**WEST SUSSEX COUNTY COUNCIL
STRATEGIC PLANNING CONSULTATION**

APPLICATION NO: Y/56/13/

Site Address: Berricourt Main Road Yapton BN18 0ED

Description of Works: Replacement of existing defective floor joists at second floor level, Pitched and Flat Roof to existing Listed Building with new access gate from Main Road. This application affects the character and appearance of Yapton Conservation Area

Proposed Gated Plan Entrance @ 1:100

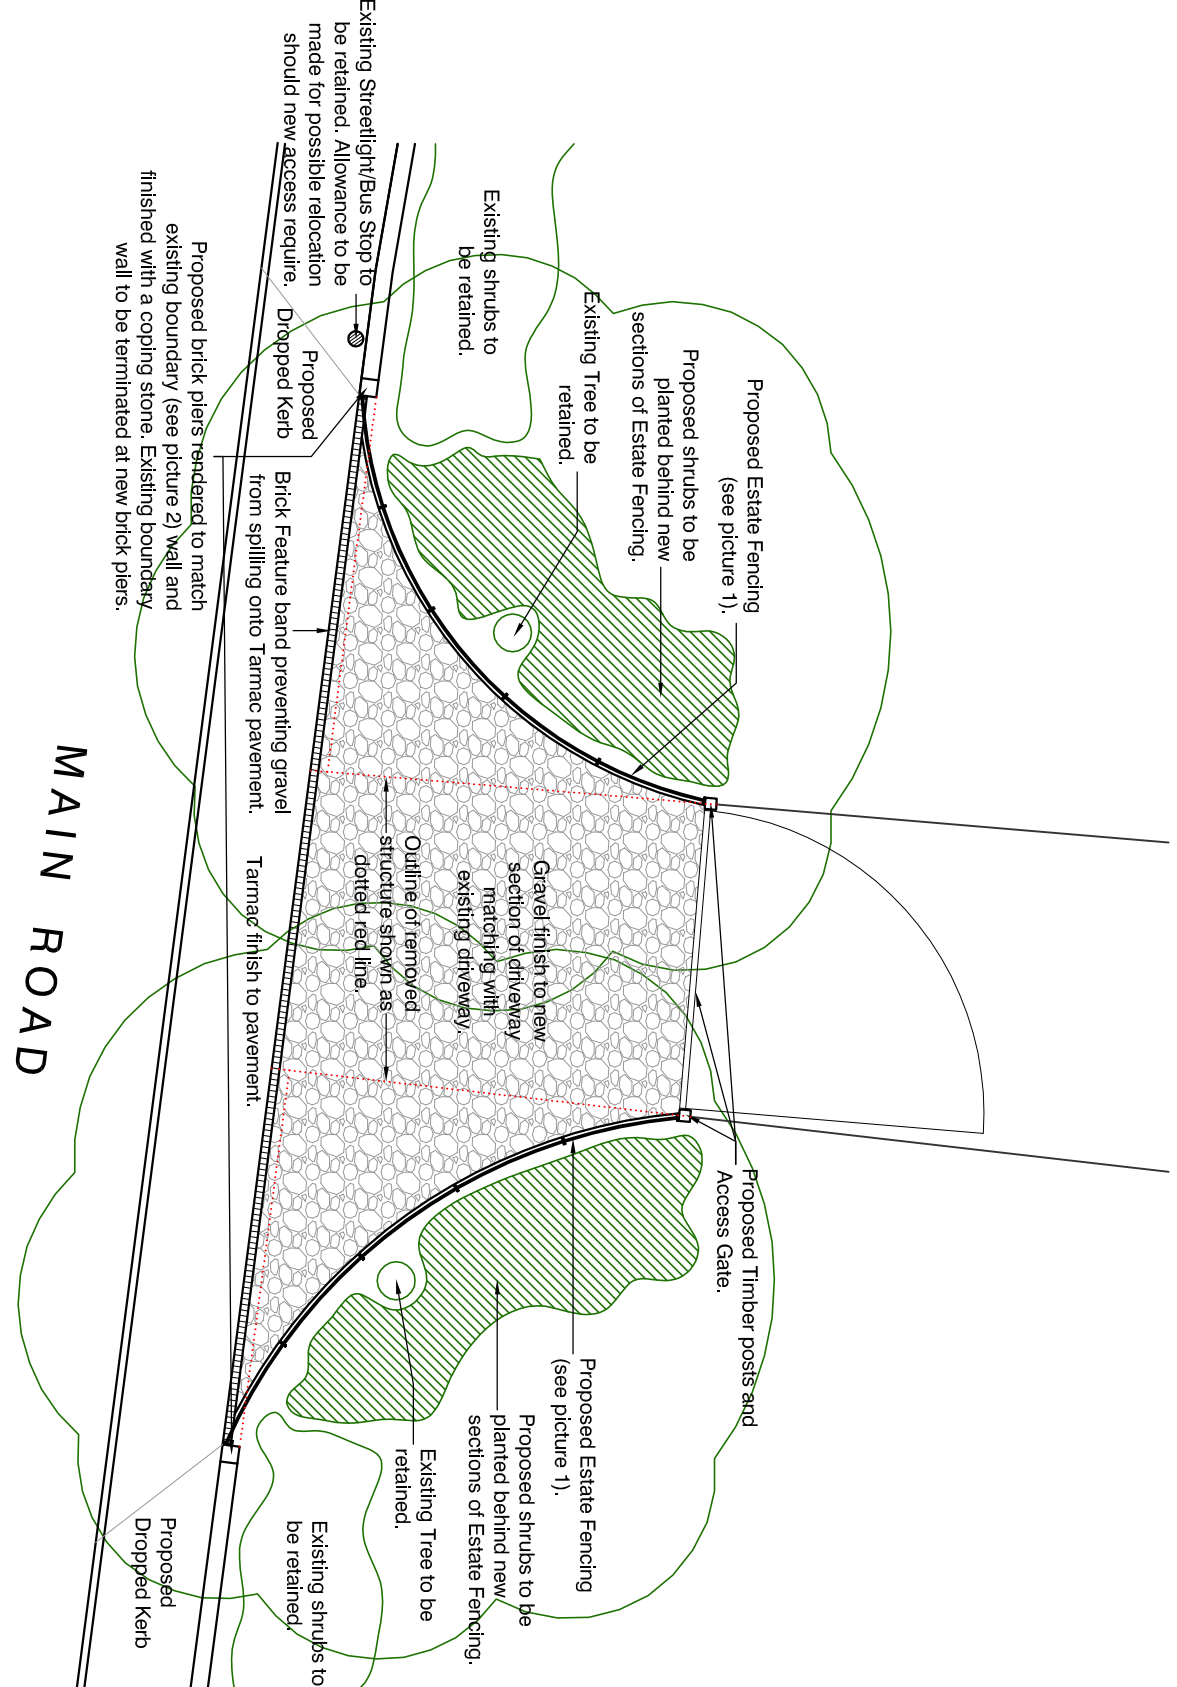
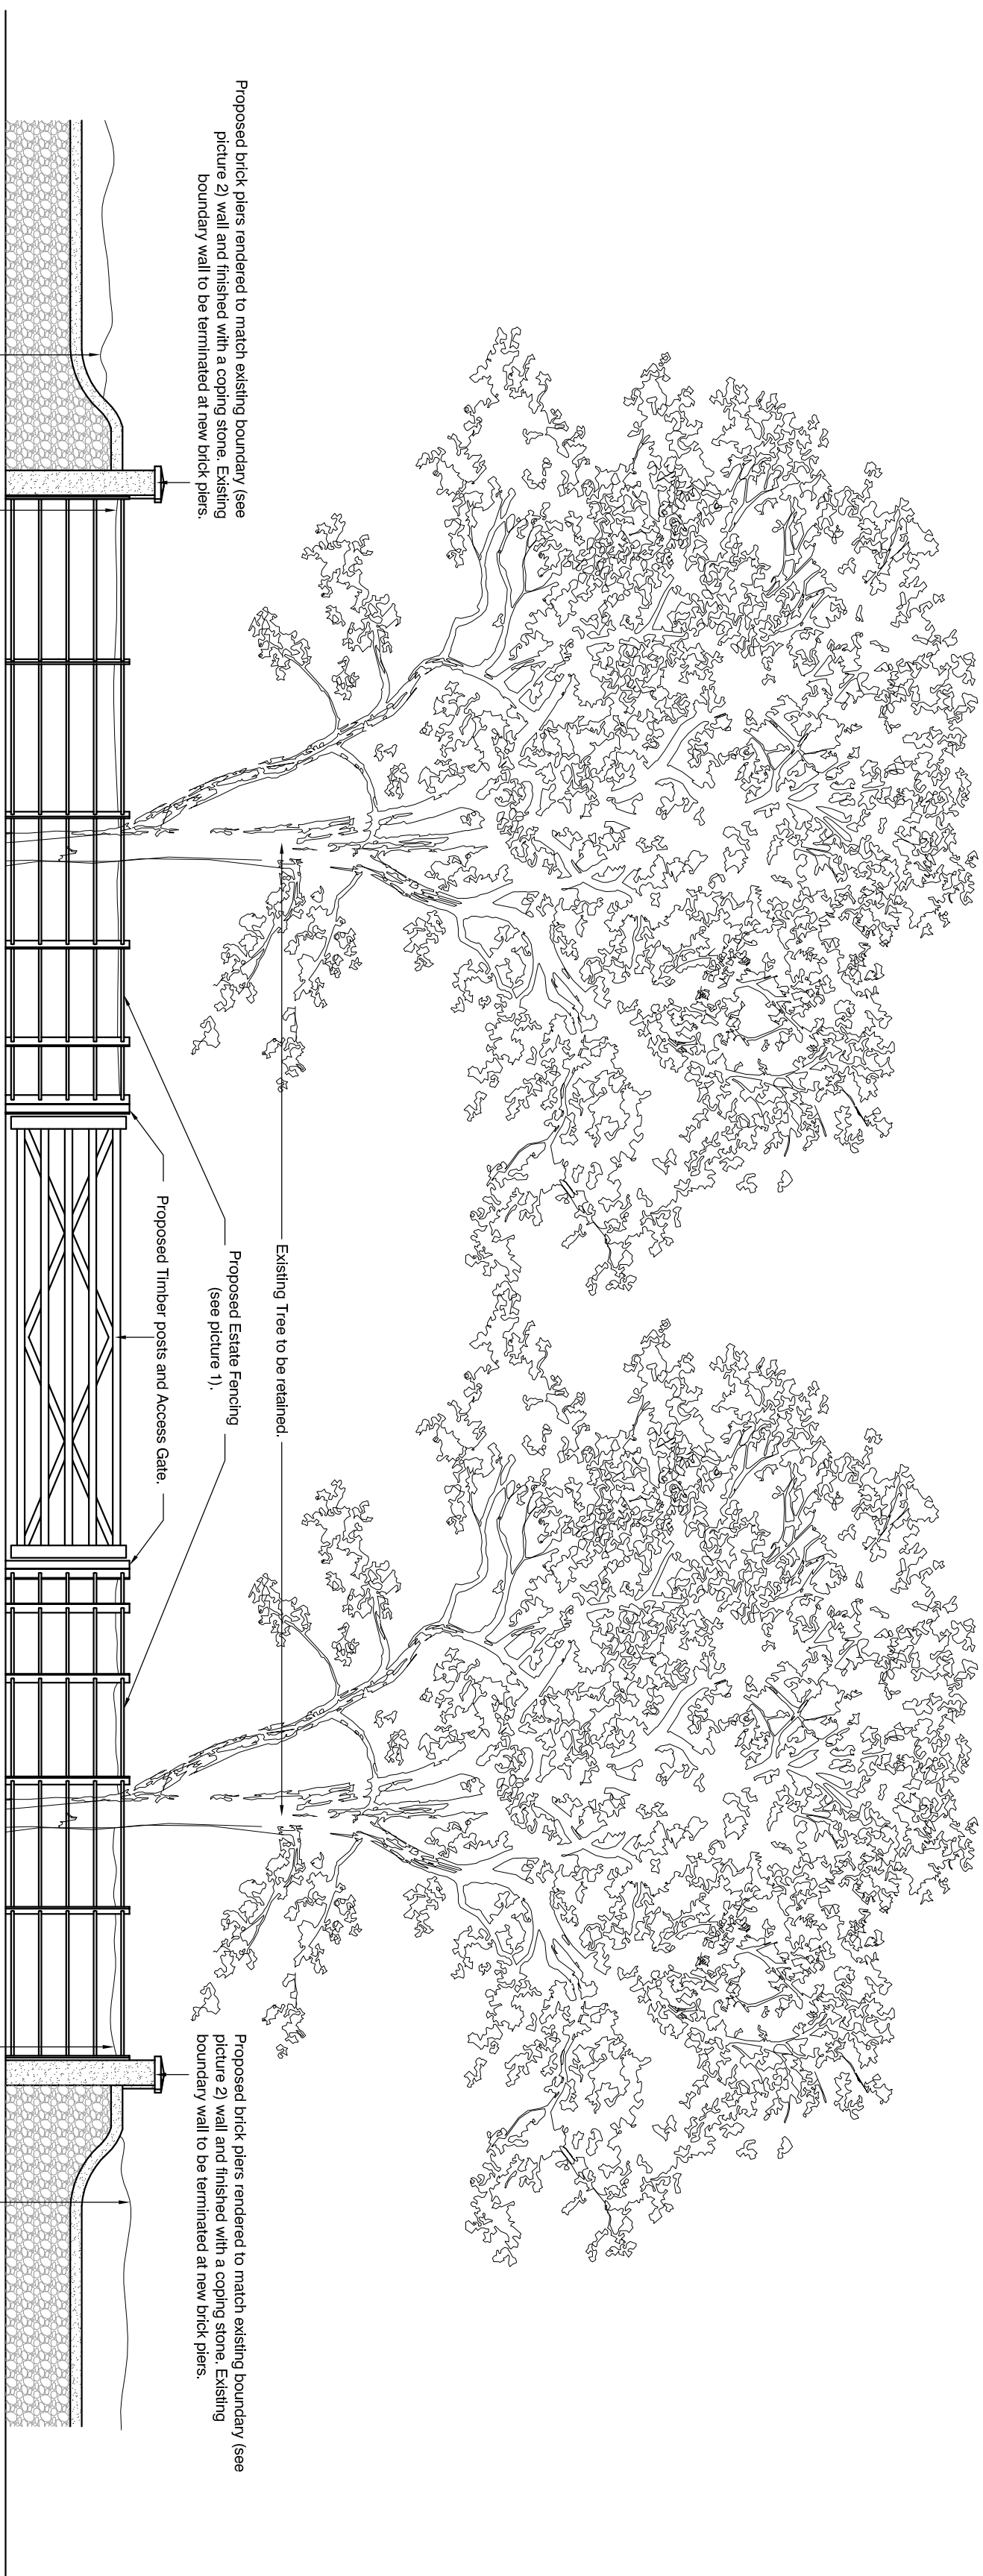
In principle no concerns would be raised to this application. The proposed gate opens inwards of the site, I would advise that a condition is attached to any planning consent securing the proposed gate and its positioning.
